R/192/21/L

Hobbs Farmhouse 36 Sea Lane Rustington BN16 2RE

Listed building consent for erection of single storey rear extension to create orangery and creation of en suite on first floor following the demolition of existing outhouse.

Drawing: Proposed Elevations

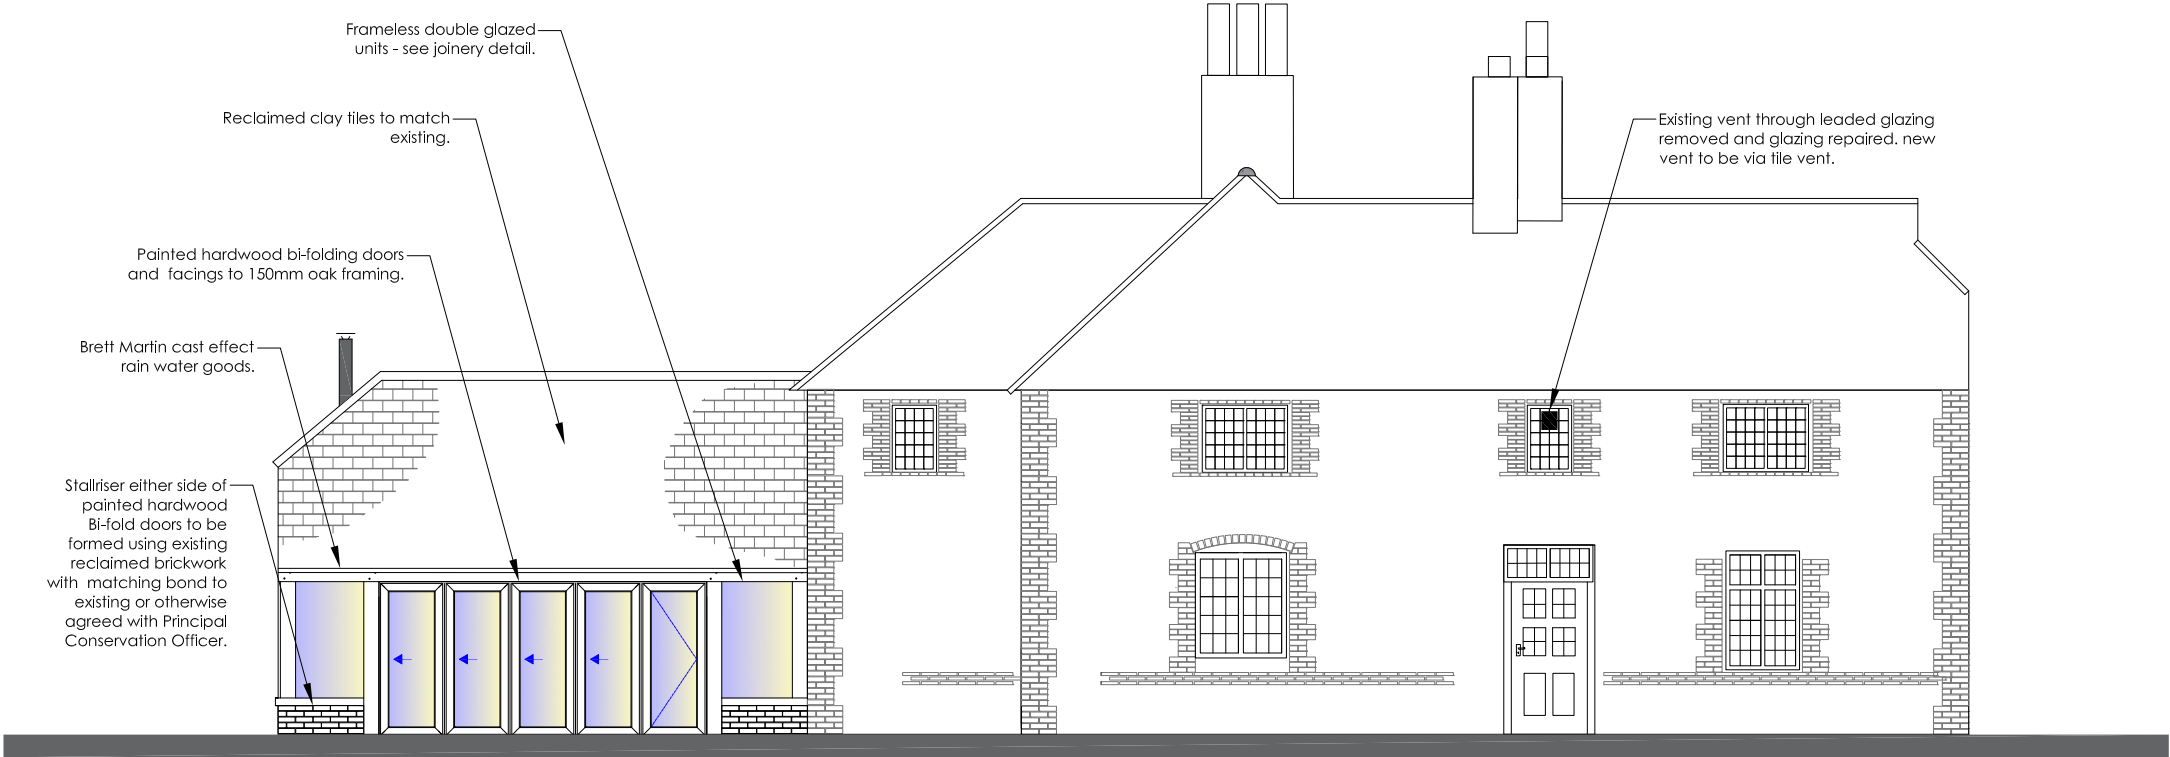
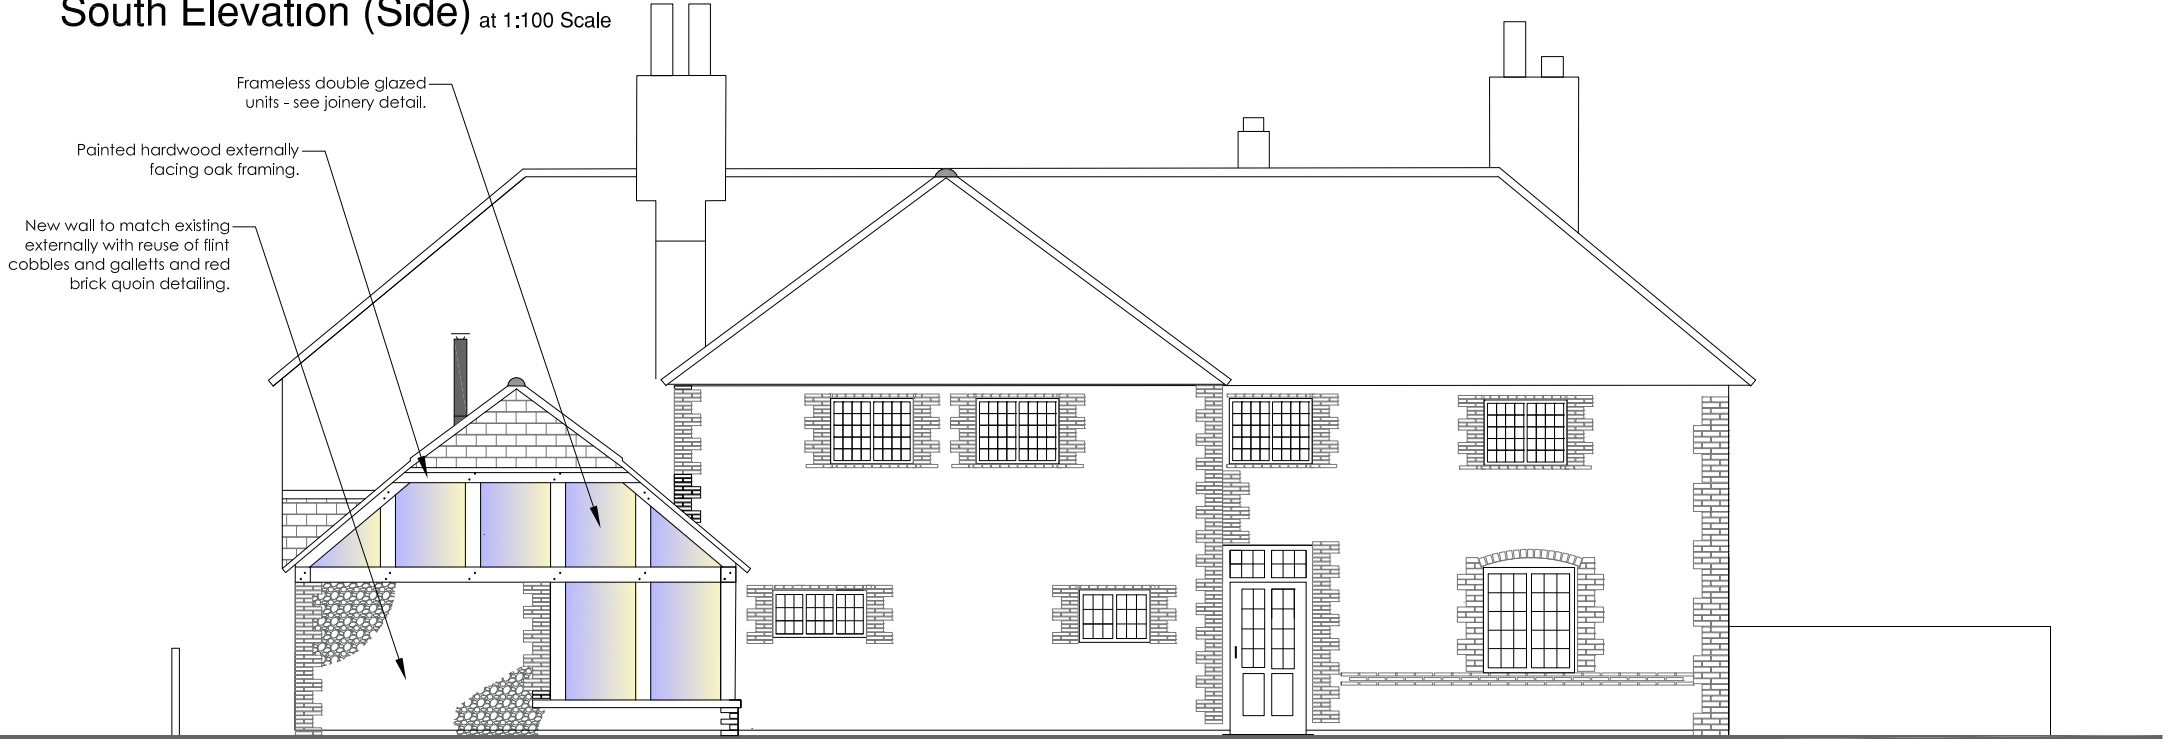
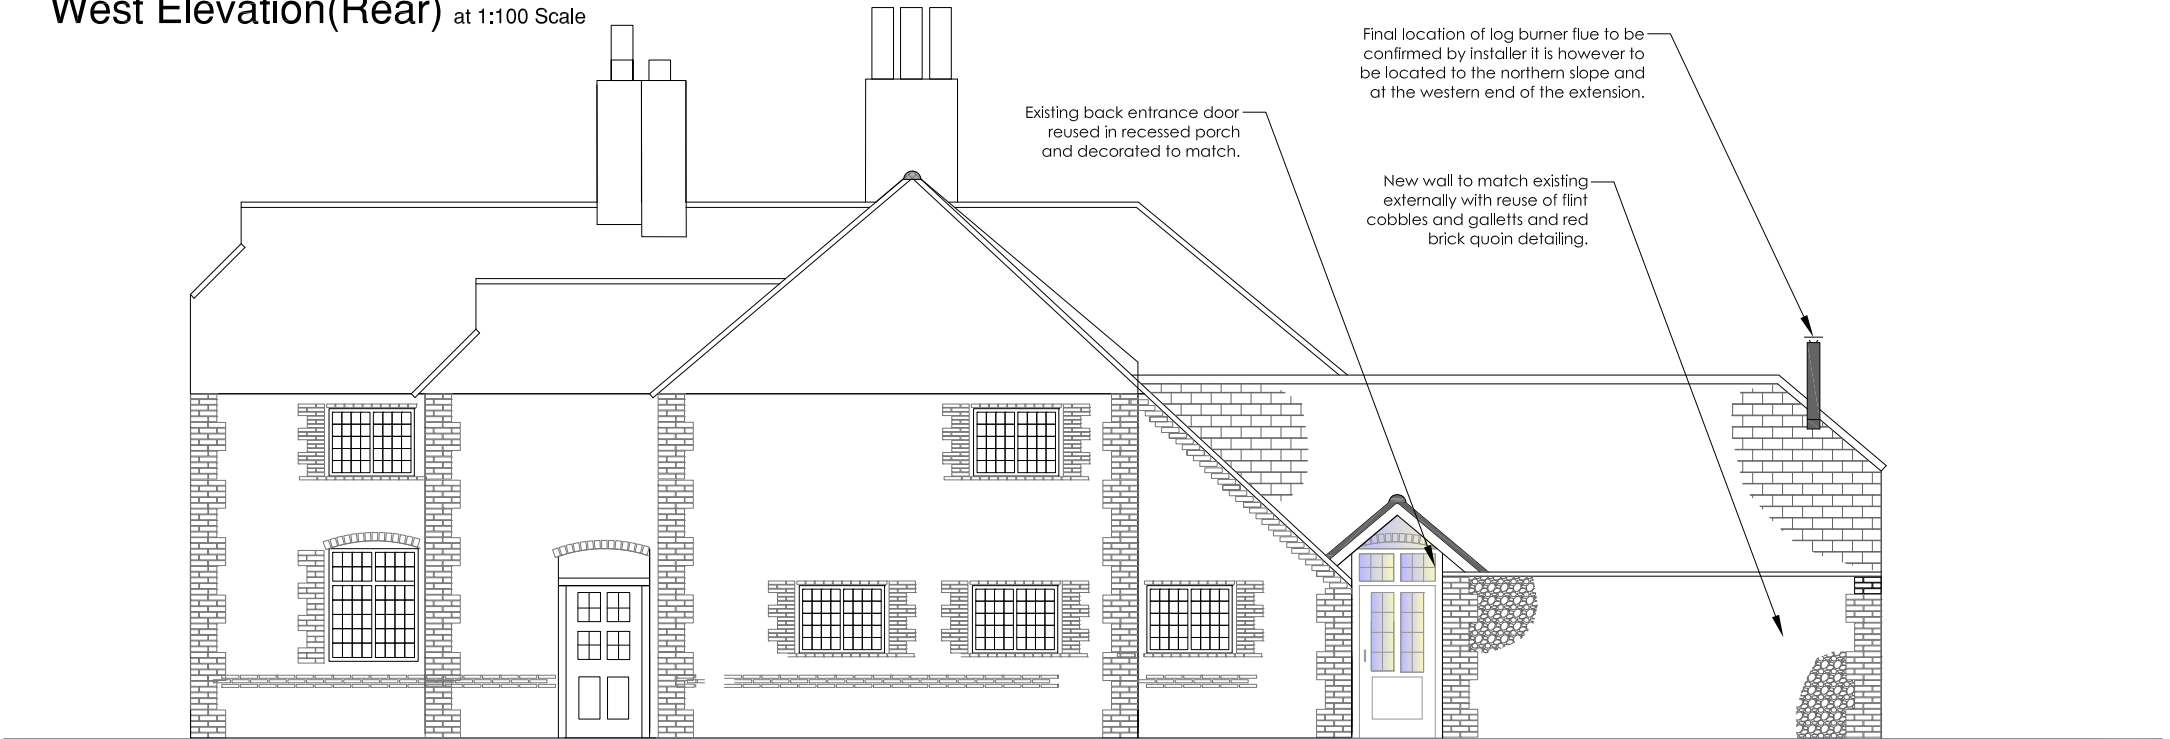
Whilst the proposed extension is larger than the existing structure it will provide for a usable space, as opposed to one that is barely suitable for storage. It will incorporate positive elements and materials of the host building whilst appearing as a simple modern addition. I am of the opinion that it will still read as a subservient addition to the host building and is generally acceptable. The removal of the existing rear door and its re-use in the extension is also acceptable as it is an example of the sustainable re-use of traditional joinery.

The success of the addition will depend upon the materials used and the quality of the work undertaken. It is positive to understand that as much of the existing materials being removed to make way for this new extension will be re-used (including the flint and red bricks). Further I am happy that the new flintwork and brick work will match the existing in terms of appearance and brick bond. I note from the Design and Access Statement that the agent states that a sample panel of flintwork will be agreed by the listed building officer on site before work on the flint wall commences. This is positive and could be included as a condition if you are minded to approve the application.

Drawing: Proposed Plans

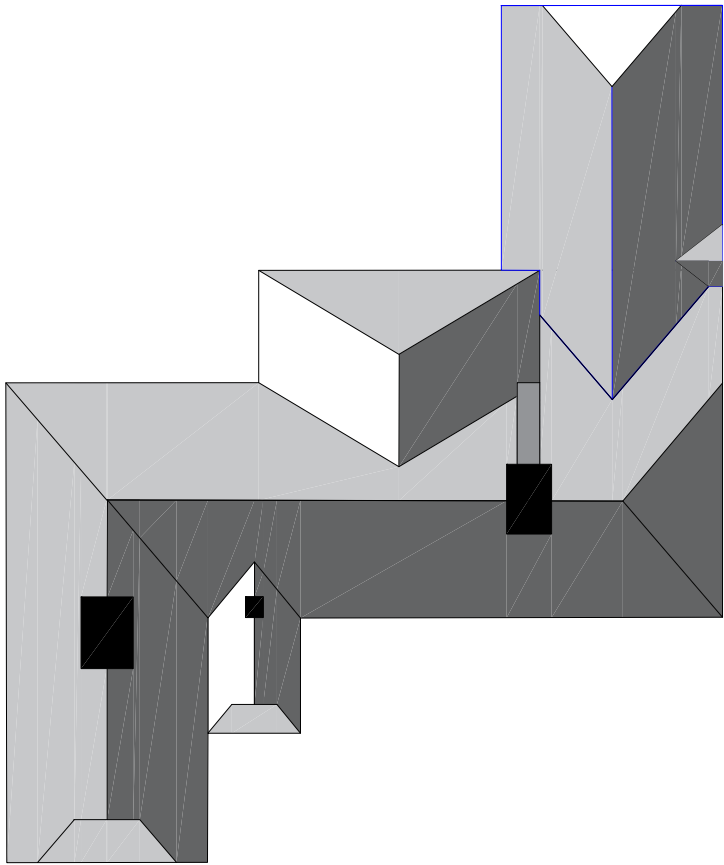
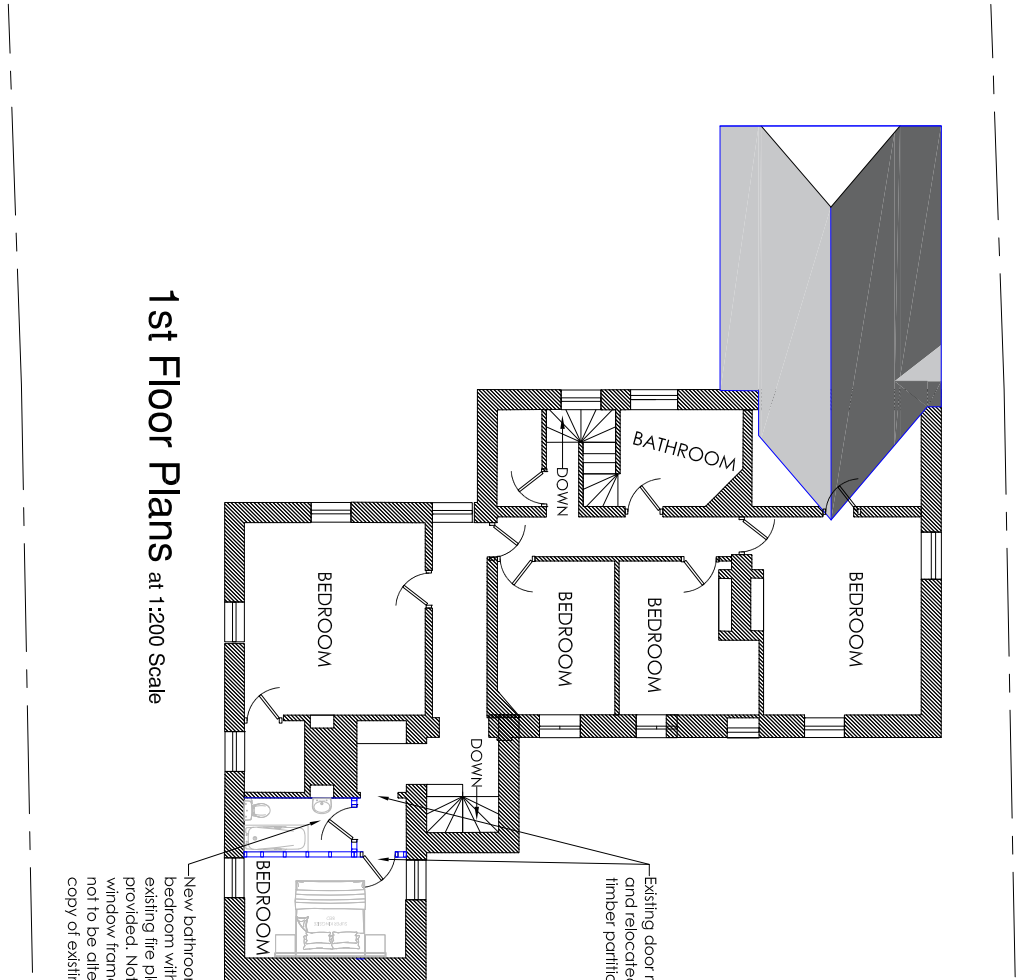
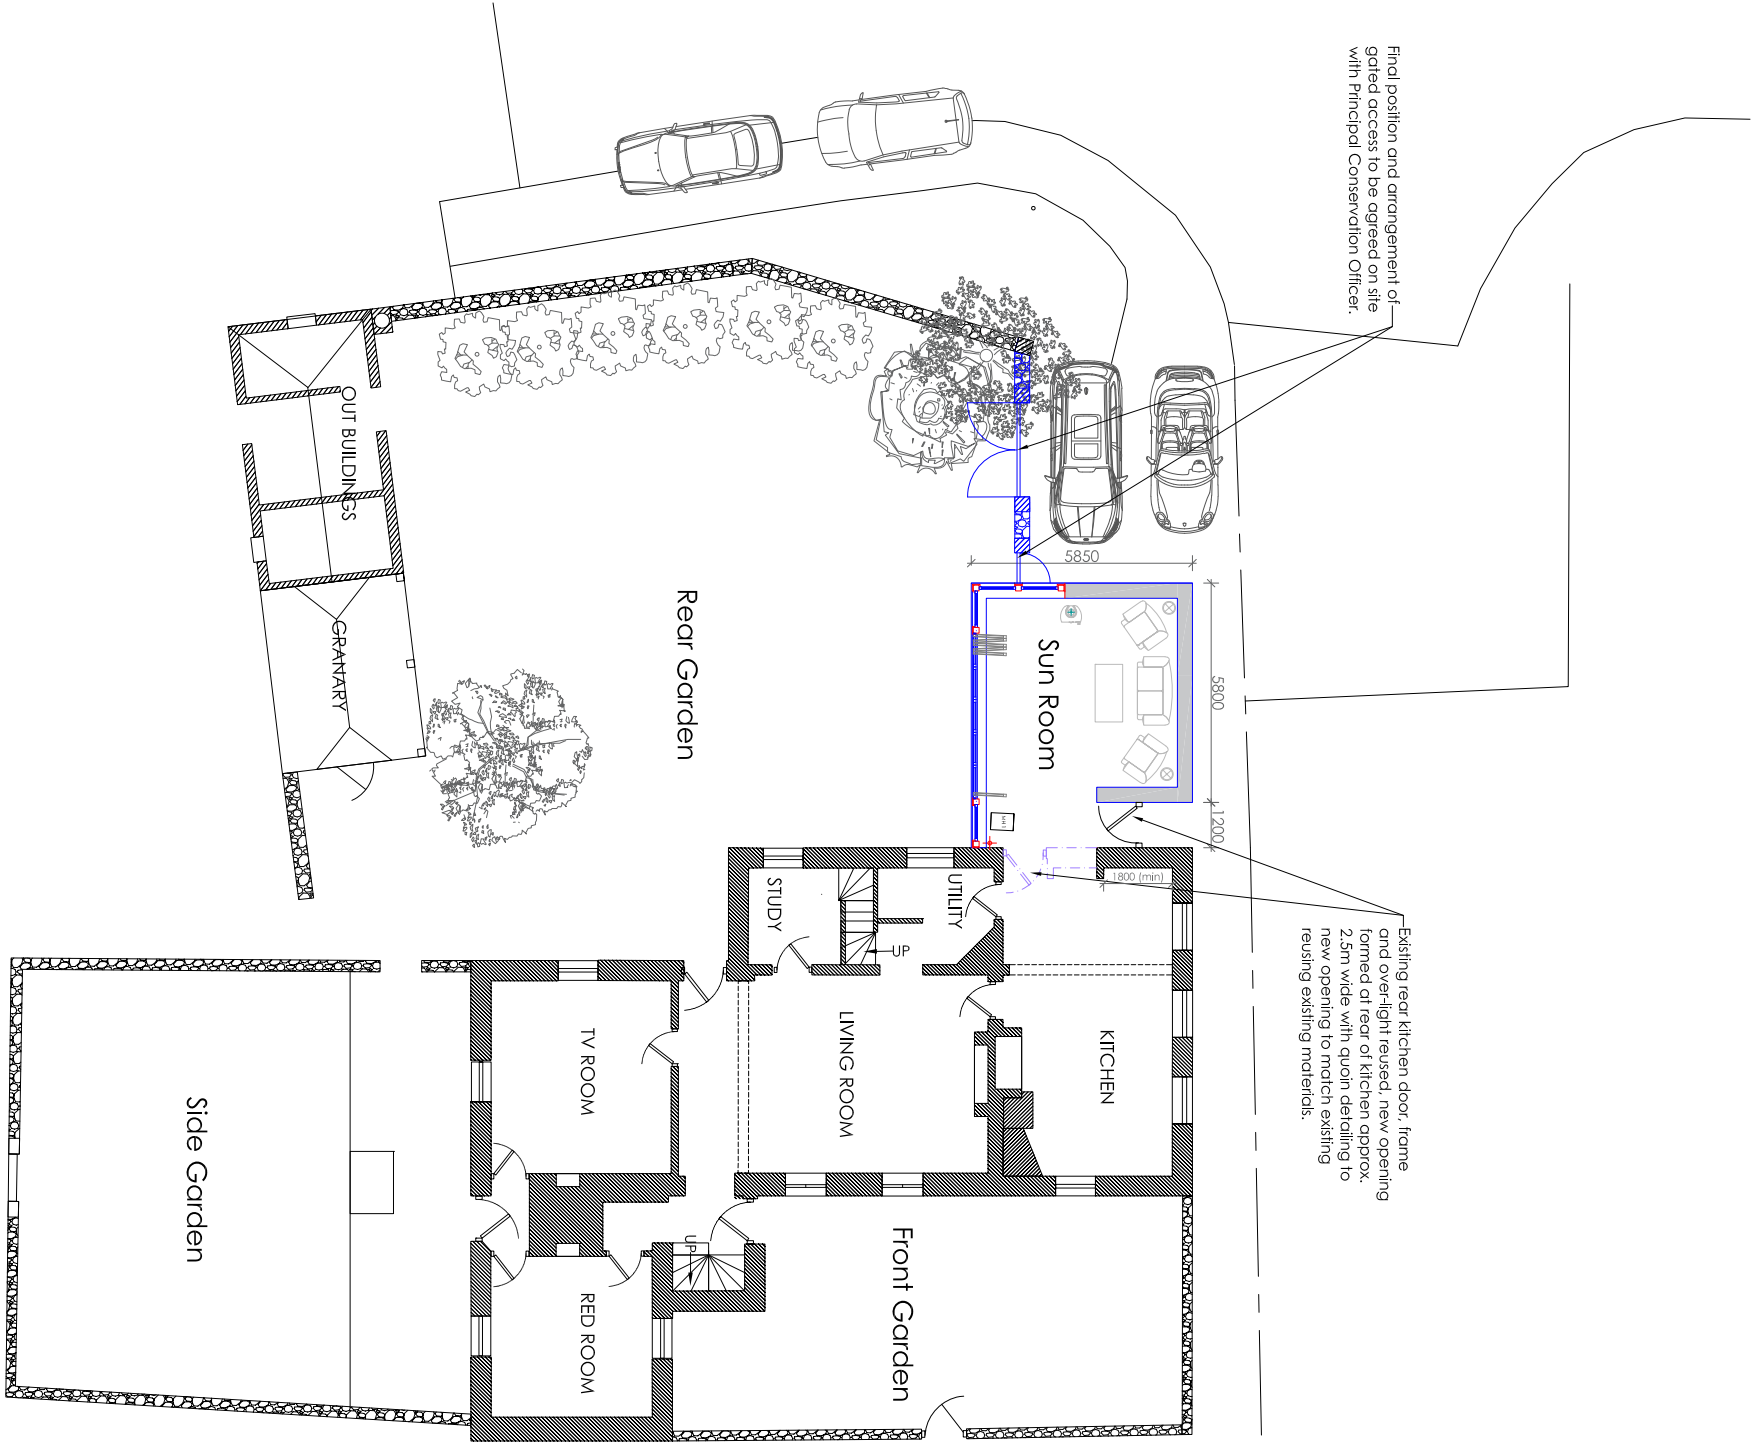
The creation of the en-suite is acceptable and the work to create it would be fully reversible. I believe that there is an en-suite in the neighbouring small room which will mean that the existing plumbing system can be utilised without the need to introduce additional external pipework. There should be no additional external drainage without plans to show the desired location. A conservation gain for this element is the removal of the existing vent in the neighbouring window.
